November 1, 2019

RE: KMART REDEVELOPMENT – DRB SUBMITTAL FOR SITE PLAN

DRB PROJECT NUMBER: PR –2019–002677
APPLICATION NUMBER: SI-2019-00252

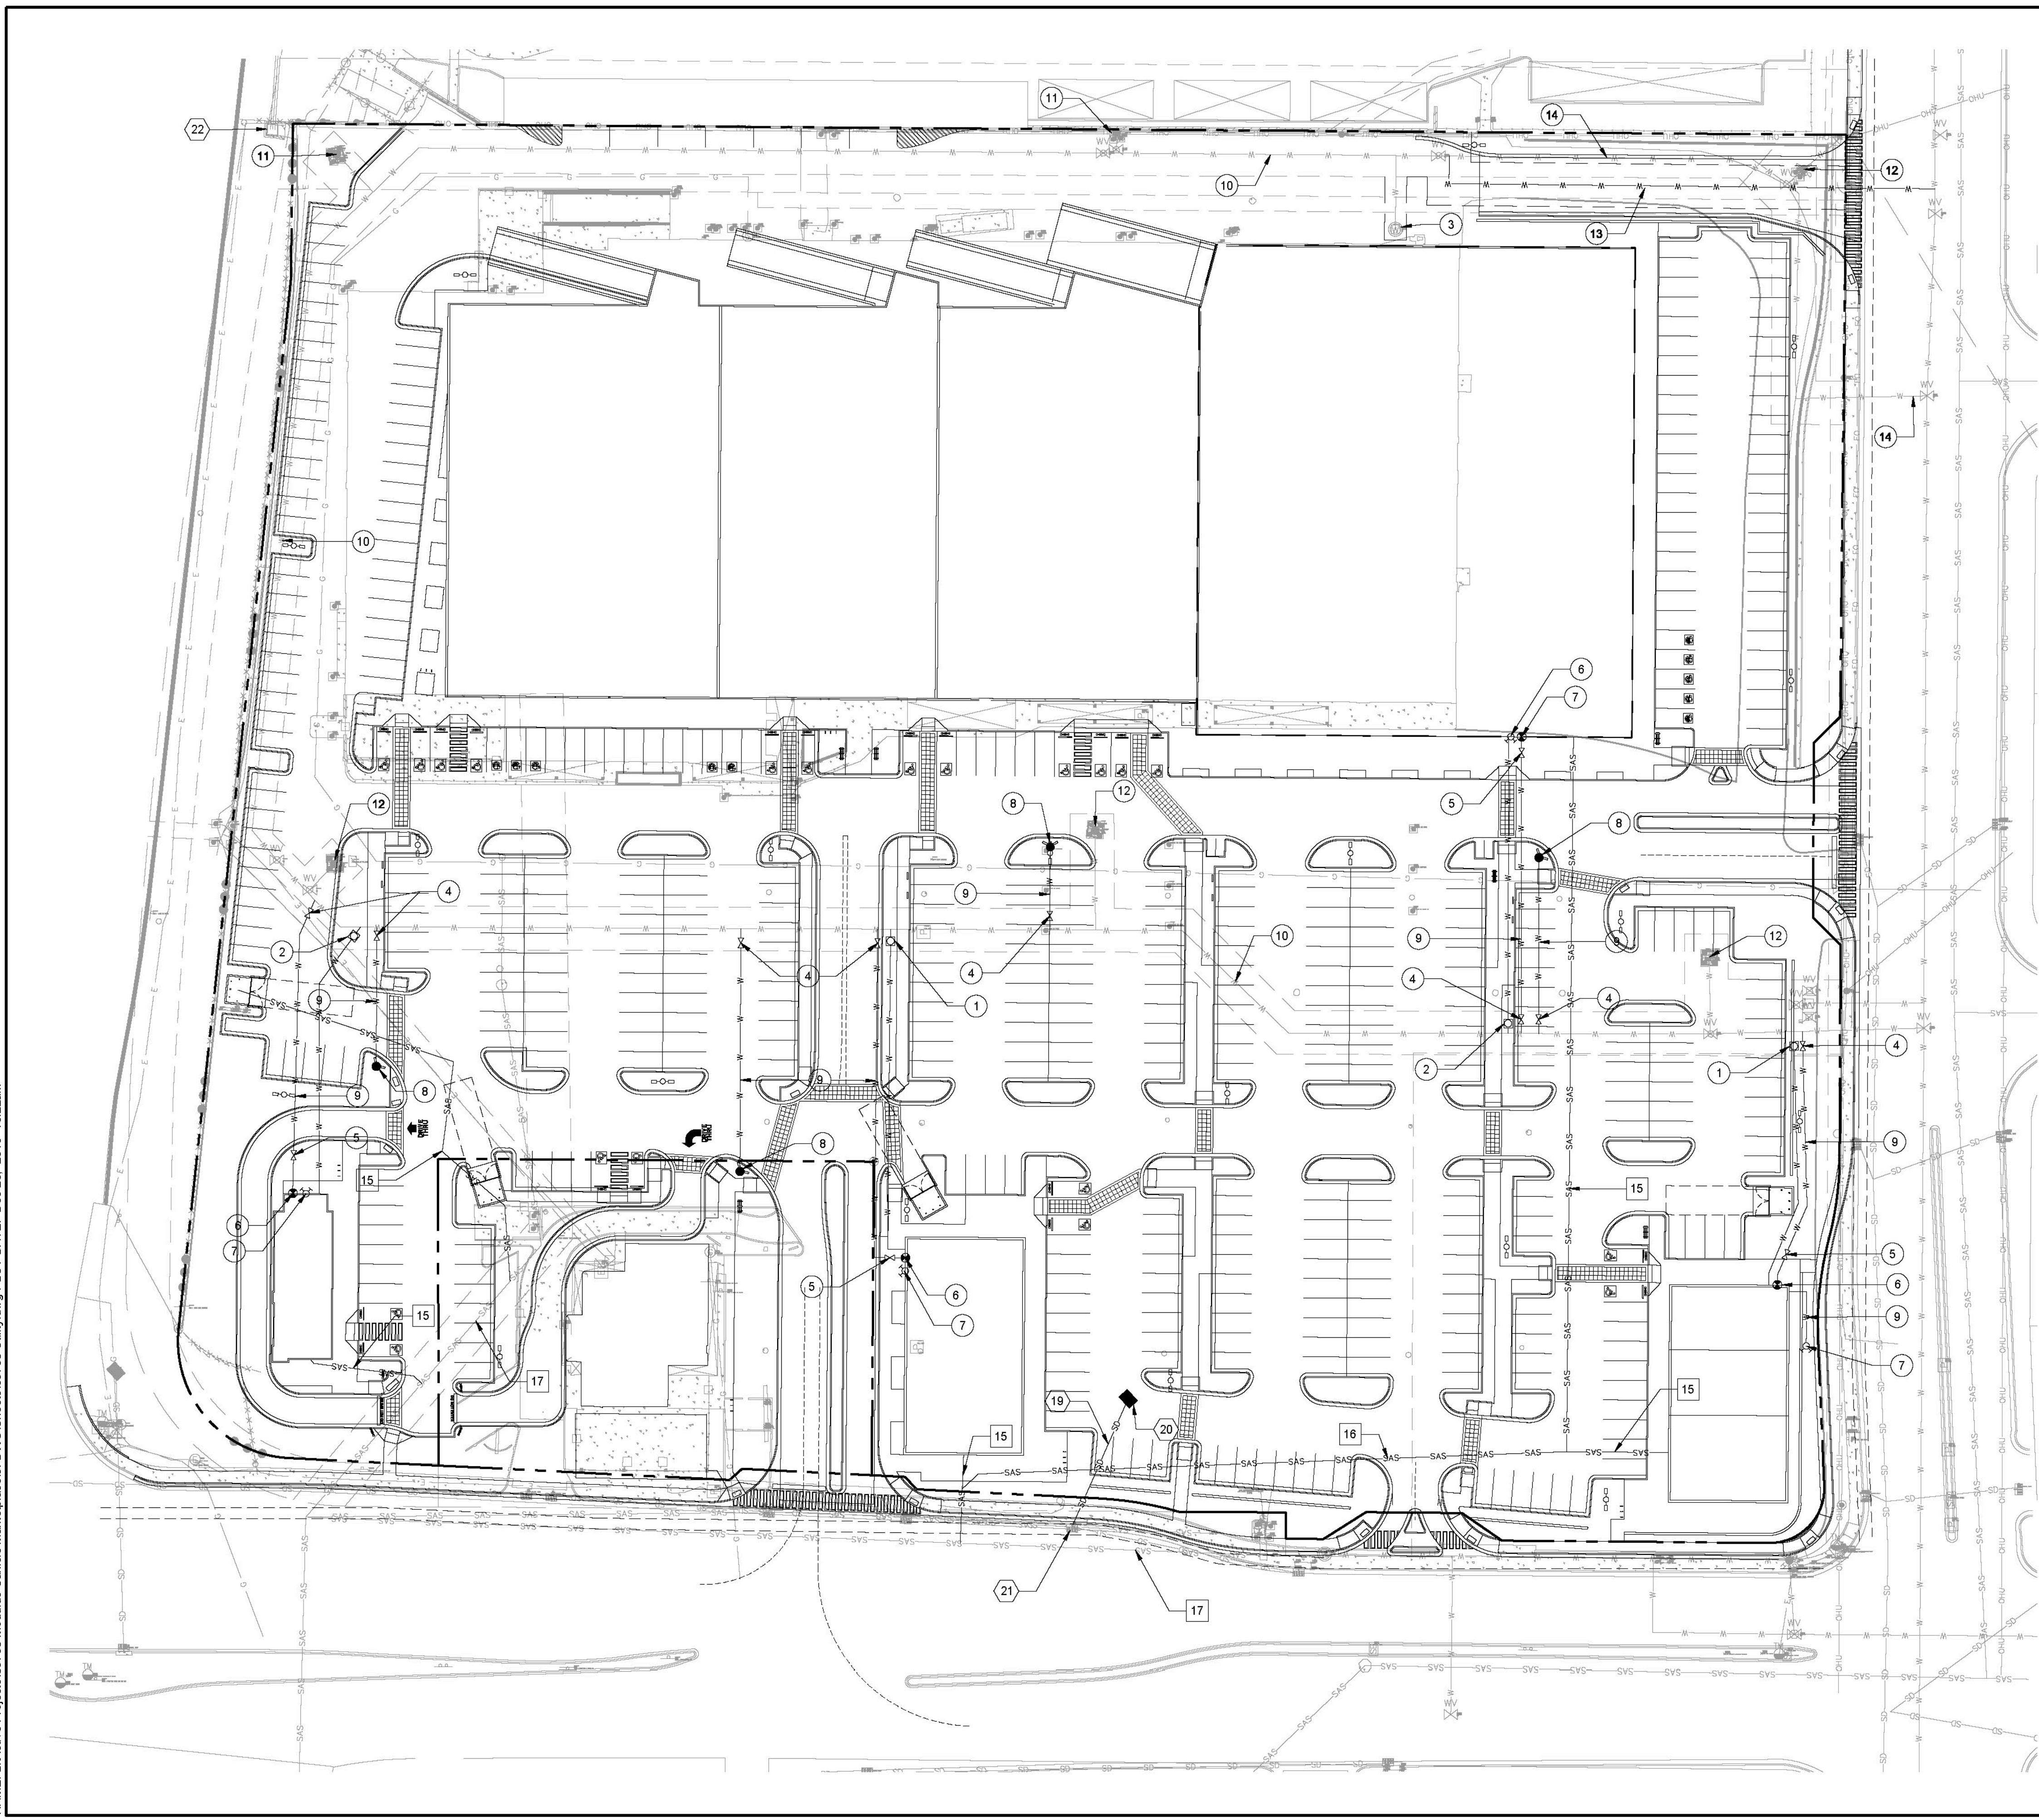
1. The proposed entrance road located at the southeast corner of the property appears to be adding fill over the existing public waterline. Deepening the waterline is not desirable. Please provide details (e.g. cross section) to illustrate how the waterline will be impacted.

2. Keyed note #9 is for proposed waterline. It shall be labeled as a private water line.
 - a. Addressed:
 - i. Keyed note #9 as shown as proposed private waterline. See revised sheet C-300.

3. Proposed onsite fire hydrants shall be deemed private. It is understood that there are several onsite public fire hydrants but the proposed fire hydrants legs are quite and resemble a private fire line.

- a. Addressed:
 - i. The existing waterline will be removed and replaced with a new waterline that follows the proposed grade of the ramp up to Indian School where a new connection to the main will be made. See revised sheet C-300.

- a. Addressed:
 - i. All existing and proposed hydrants are now shown as private. See revised sheet C-300.
4. Minimize the length of the public water service by locating proposed water meters in areas closer to the public main in areas that are free from traffic.

- a. Addressed:
 - i. Water meters have been relocated to minimize the length of public water service. See revised sheet C-300.
5. The proposed manhole for the proposed 6" sanitary sewer service shall be located in a way that allows proper access by a Vac-truck. The front of the truck should be able to drive up to the manhole.

- a. Addressed:
 - i. This sanitary sewer service alignment has changed. See revised sheet C-300.

SHEET NO.: **A201**

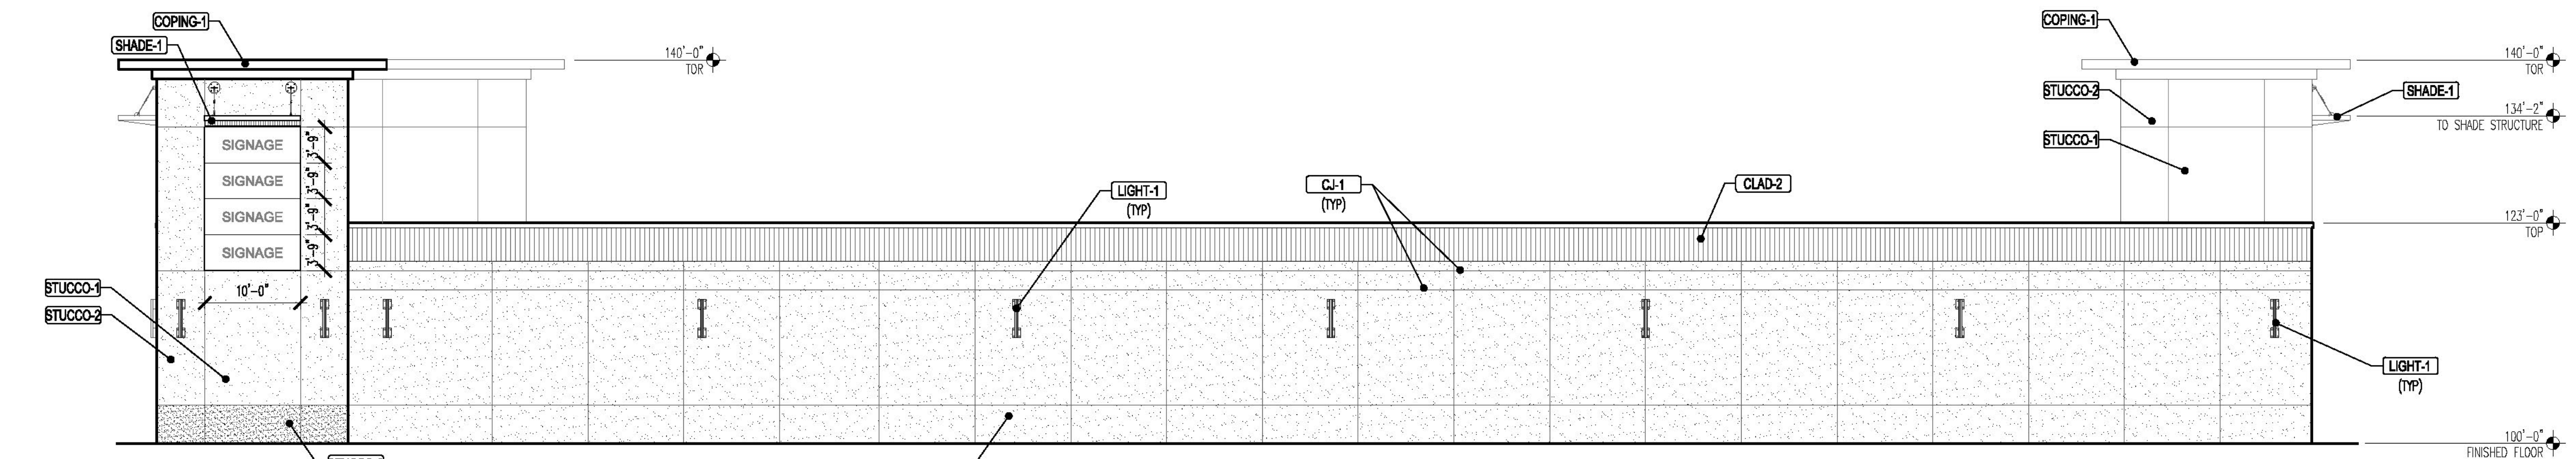
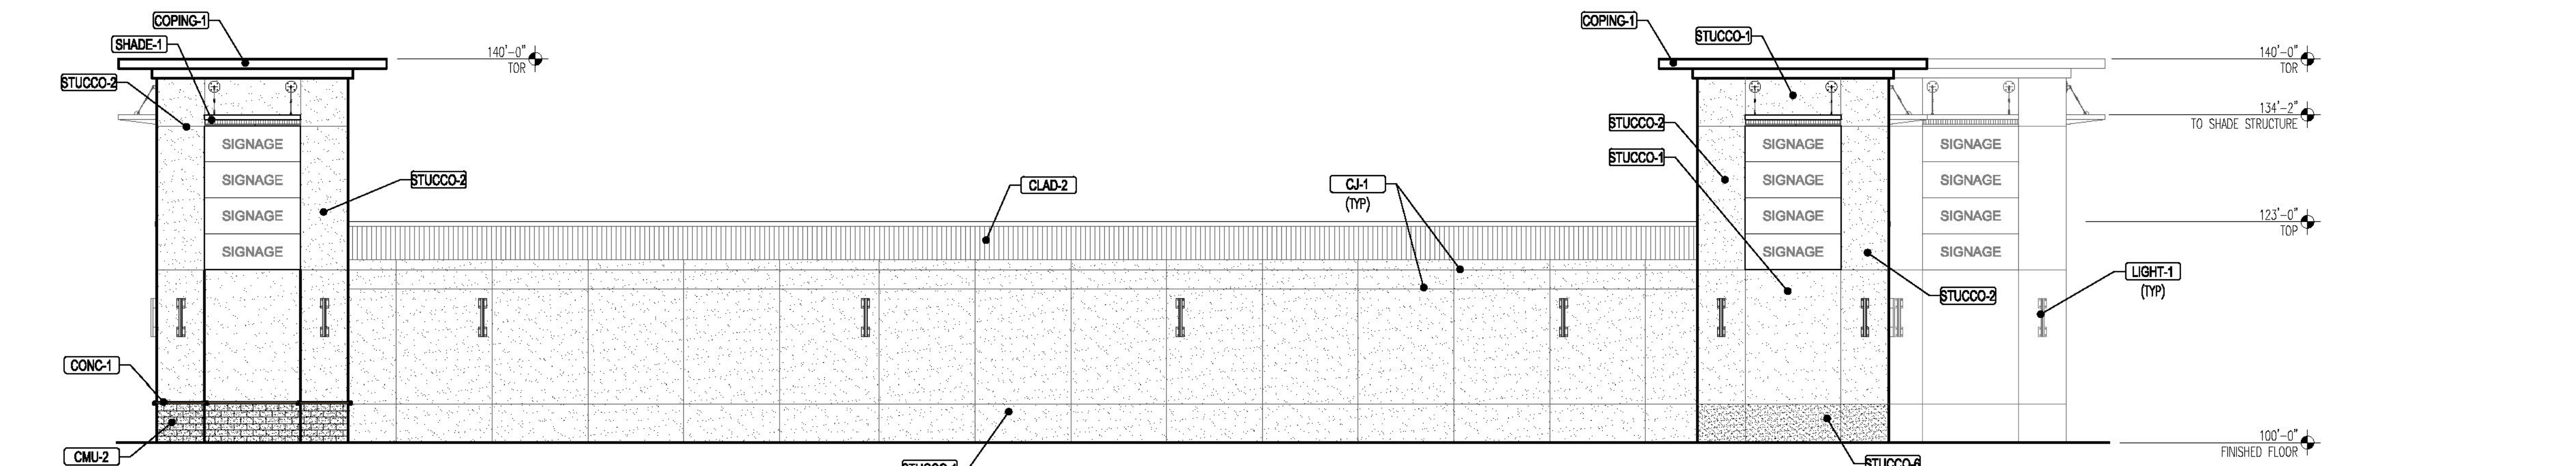
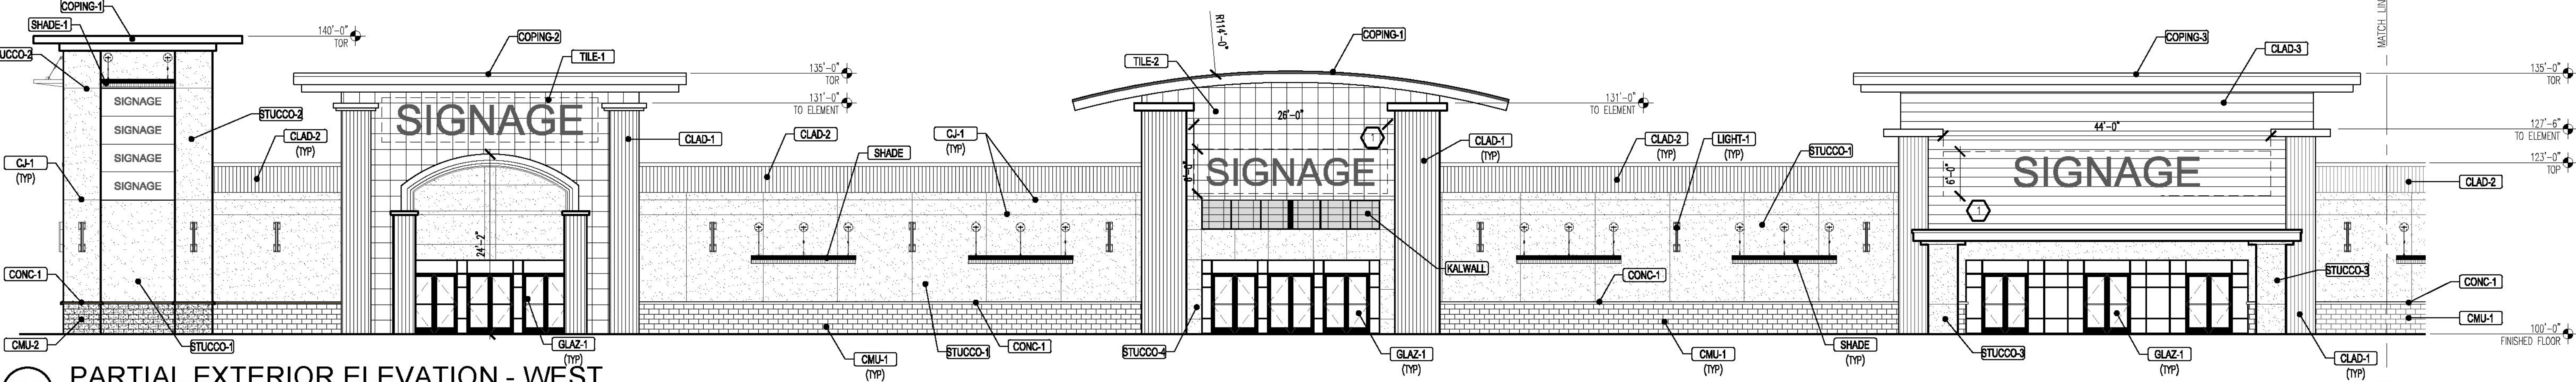
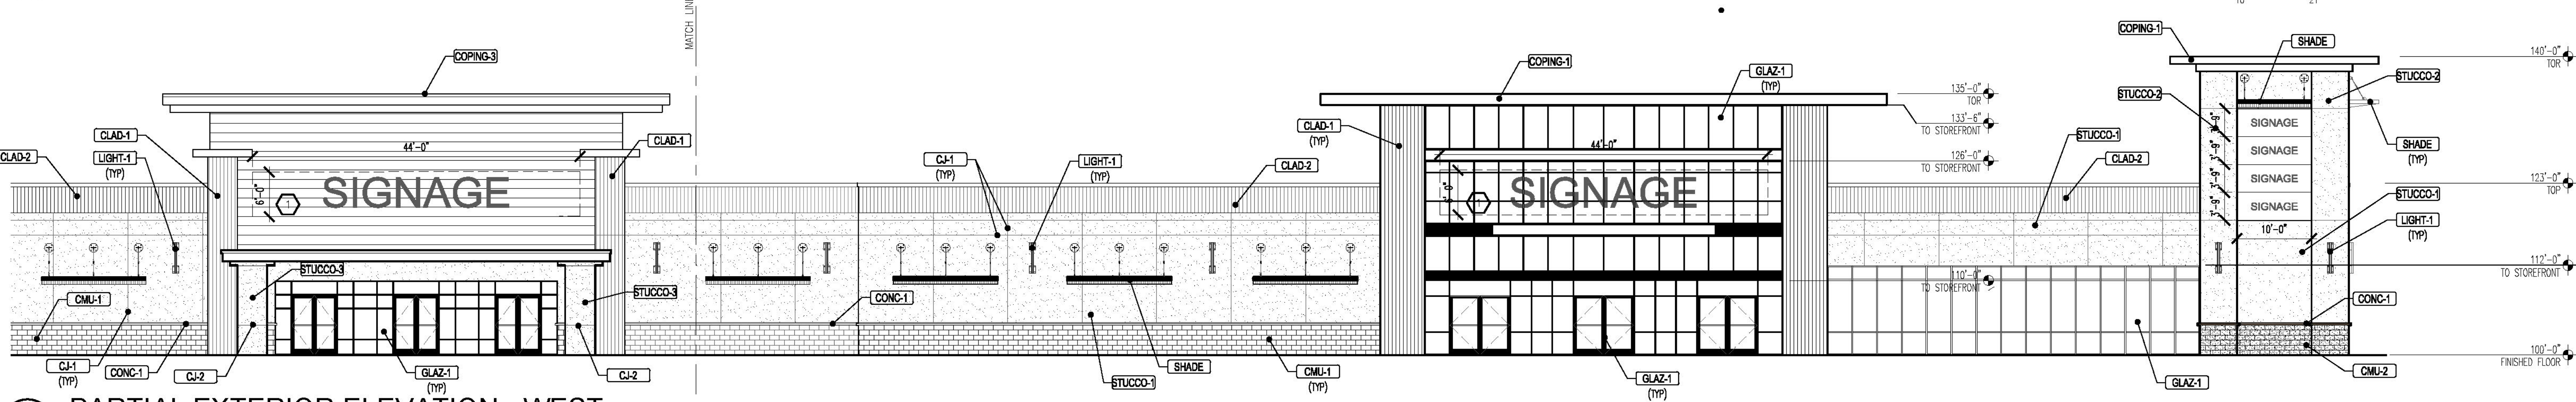
2. 10 electric vehicle spaces are required.
 - a. Addressed
 - i. See new parking calculations in the Site Data Table on BP-1 also see note 31 (10 spaces added).
3. A 15 foot sidewalk is required along the main building, please provide or request a deviation.
 - a. Addressed:
 - i. We maintain the overall 15' sidewalk along the main building but there are certain pinch points that don't meet the standard. A deviation will be requested.
4. See section 5-11-(E)(2)(a) for façade requirements- north elevation does not look like it meets these.
 - a. Addressed:
 - i. Planters where added on the North side see BP-1 – Note 11.
 - ii. Façade elevations where adjust to meet code – See A201 - C1 North Elevation.
